January 24, 2024

RE: Responses to Technical Review 1
White Barn Brown Bear Car Wash
8907 & 8915 Soper Hill Rd
City File No. PA23-021
Our Job No. 22681

Letter from City of Marysville dated December 5, 2023

03 WEST ELEVATION - AUTO SENTRY  
 CWA2.2 SCALE: 1/4"=1'-0"

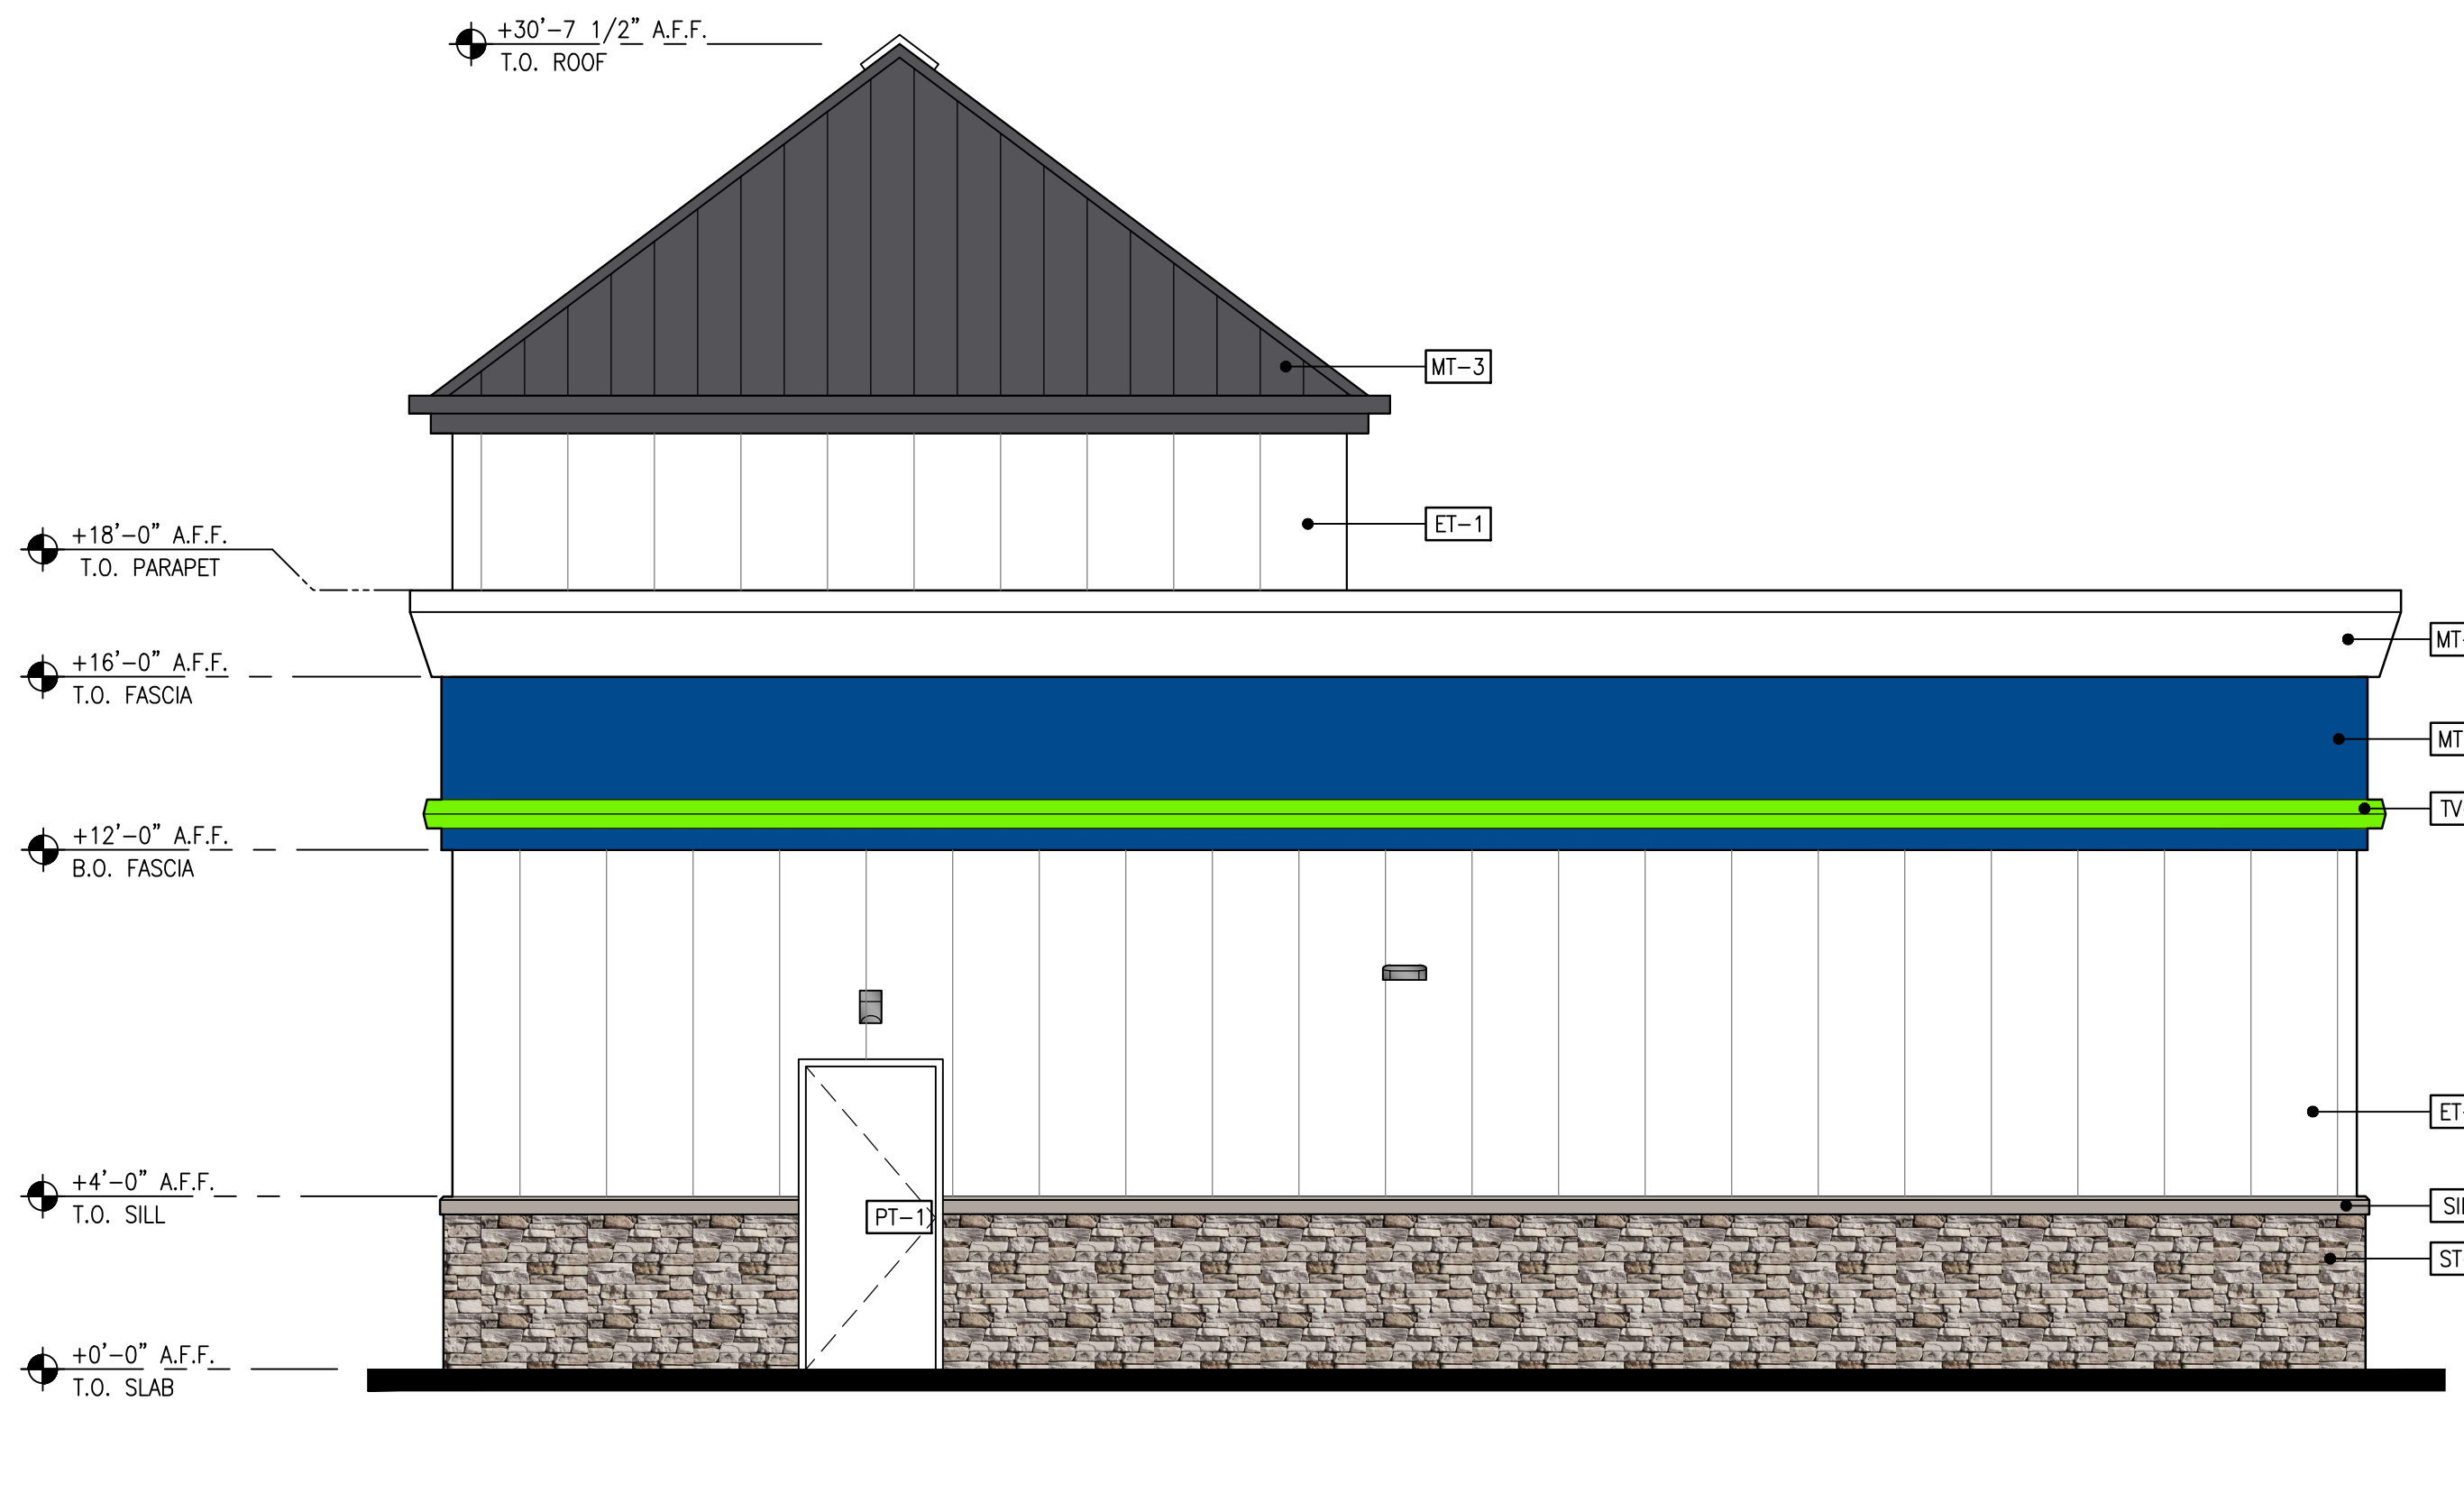
4. *To better meet the intent of MMC 2C.070.190(2) in regard to building details standards, architectural design elements should be included the windows and doors (i.e. awnings, trimming, recessed entries, decorative doors etc.).*

4.1. *Demonstrated compliance with (2)(d) for blank wall treatment is needed. Especially for the east/west elevation of the Self-Wash building.*

Response: Please see the provided revised color elevations, demonstrating compliance with blank wall treatment requirements.
